August 25, 2022

Re: PA22-017 – Marysville 172 – Technical Review 2

After reviewing the revised application materials of the above referenced proposal, the Planning Division has the following comments:

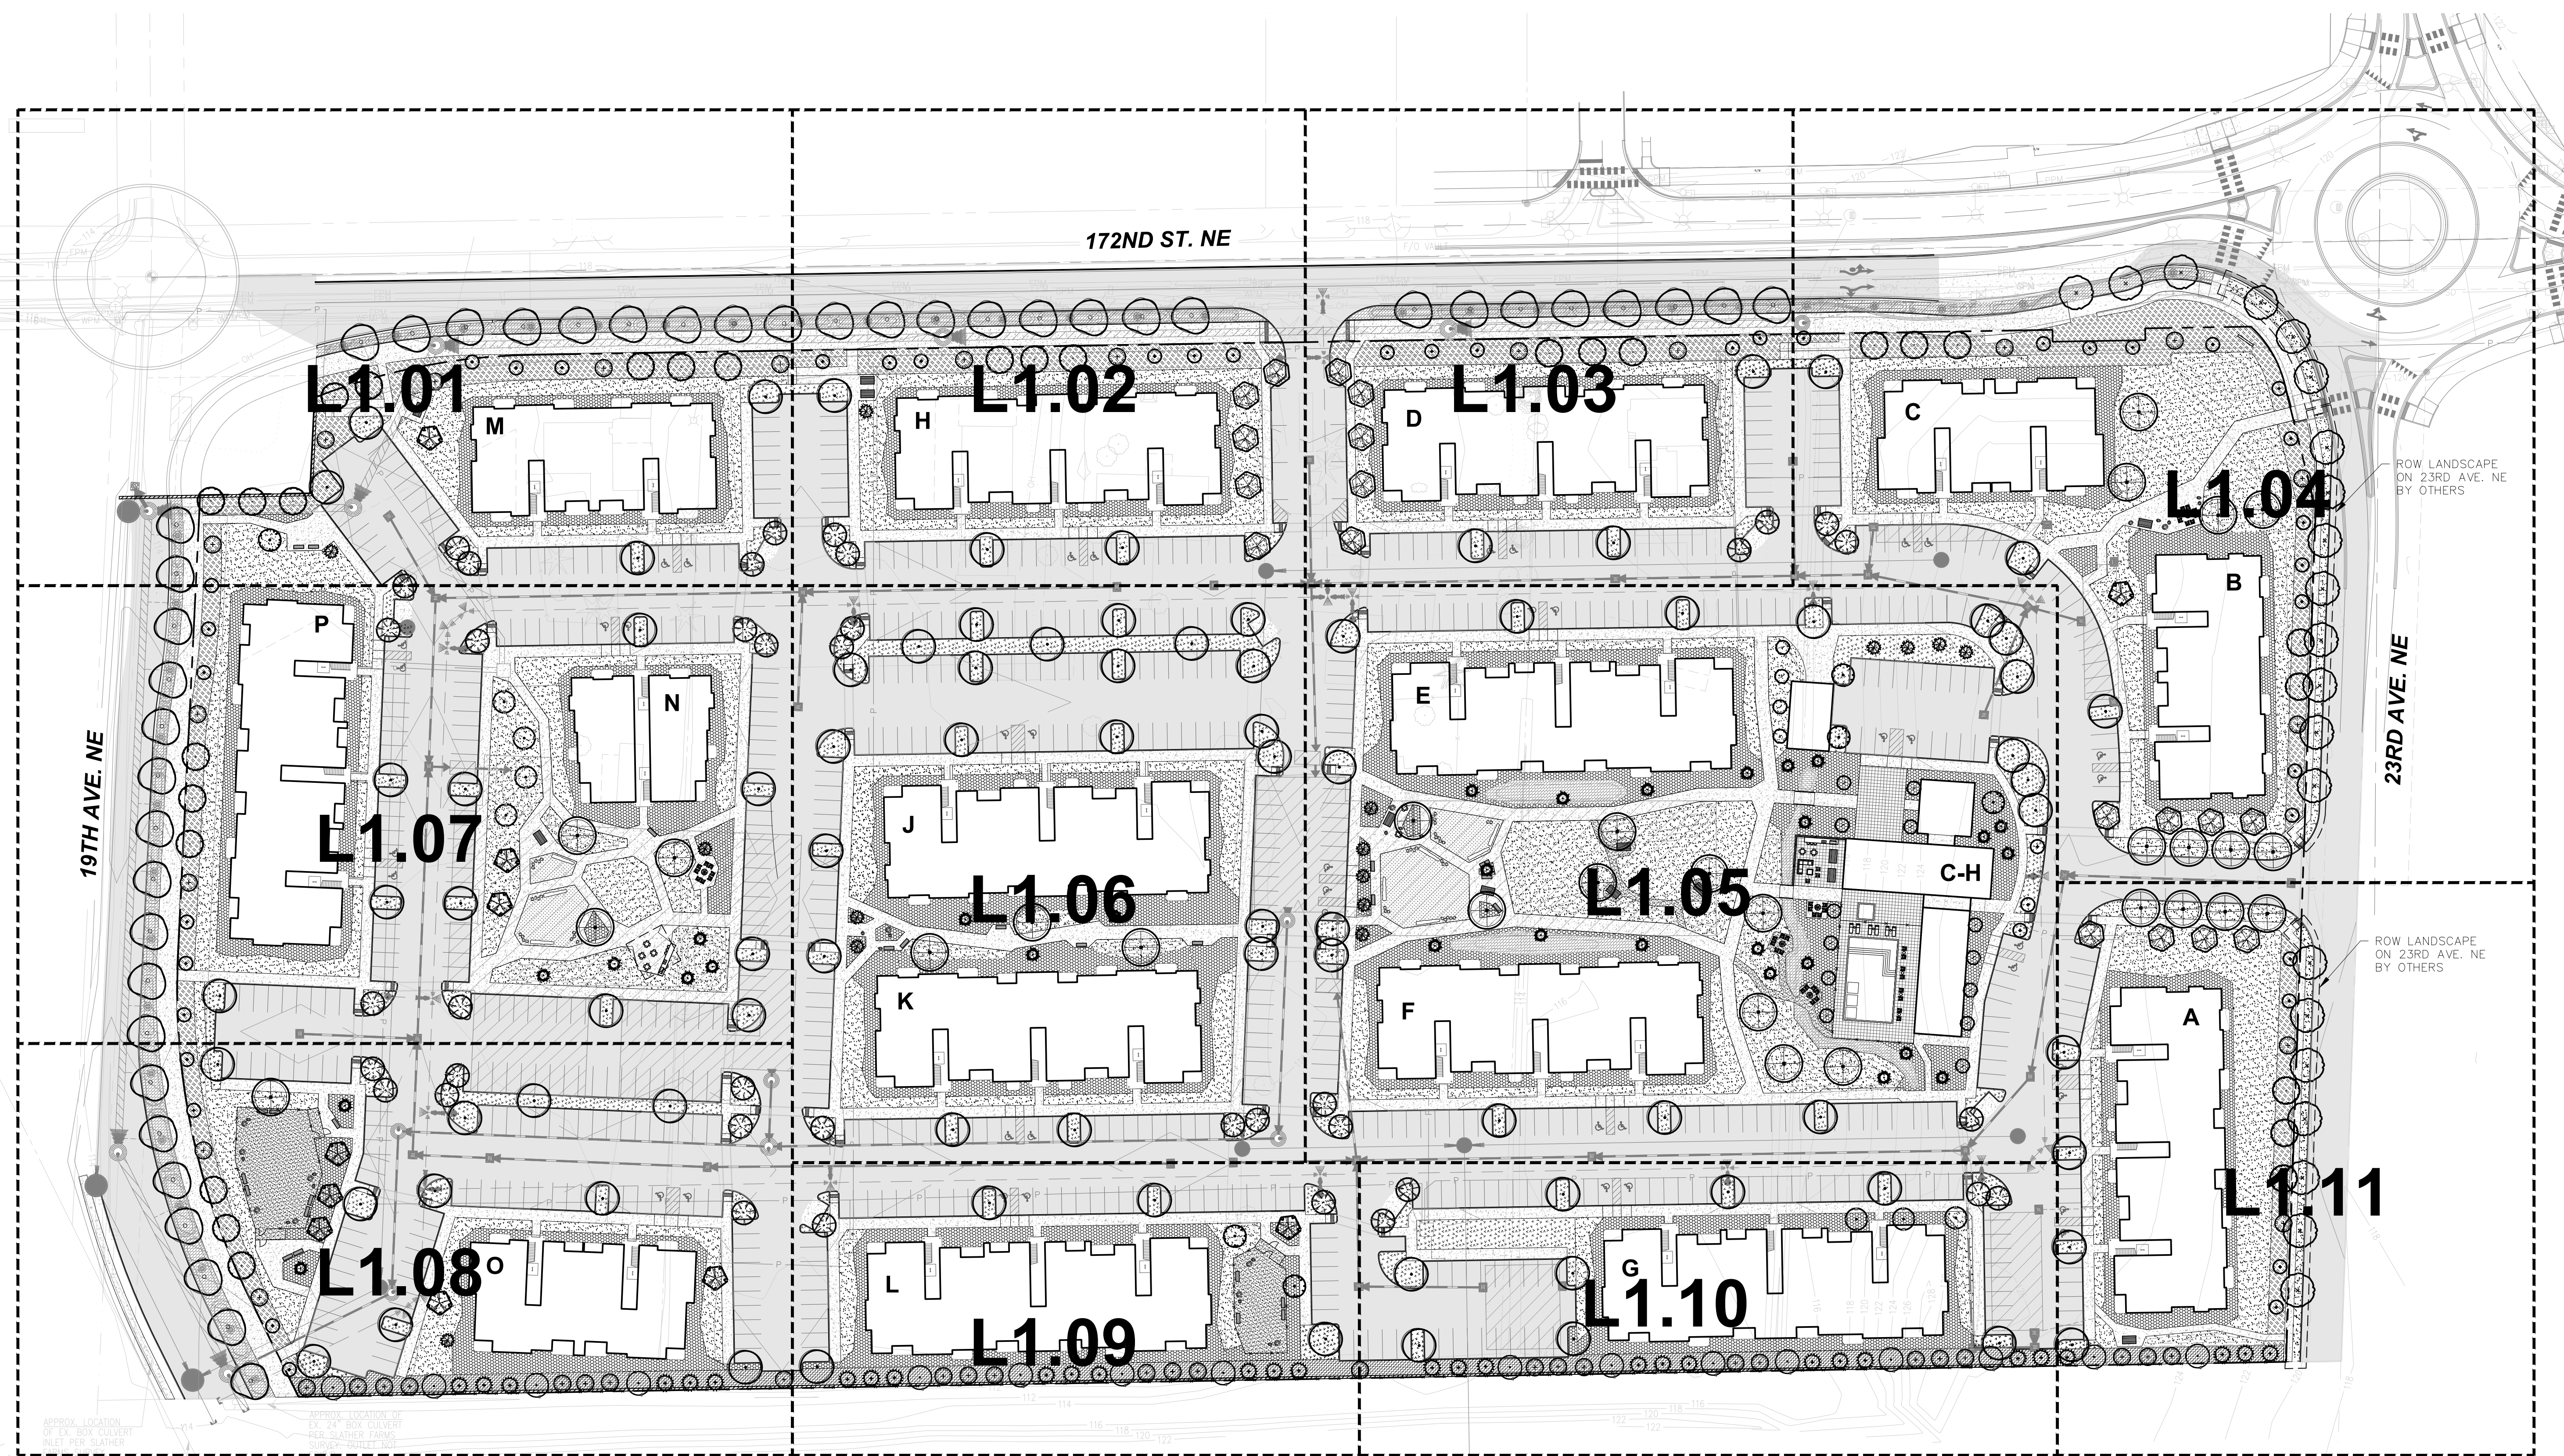
4.1. Per LNMP B.3(2)(d), the public trail area along 172nd St NE should be distinguished from a semi-private yard with a short fence, hedge, or retaining wall no more than 4 ft. in height. Revise landscaping plan to incorporate a short fence/hedge/retaining wall within the proposed 15 ft. L3 Landscape buffer.

4.3. Typical side view of perimeter landscape areas, specifically the proposed perimeter buffer landscaping.

4.4. Trash enclosures are to be fenced with a 6 ft. concrete block or brick fence/wall. This specification was not included in the site plan or landscaping plan—please confirm that the proposed enclosures would meet this requirement.

4.5. Identify areas that are to be fenced and demonstrate compliance with LNMP B.11 for the proposed height/material of the fencing.
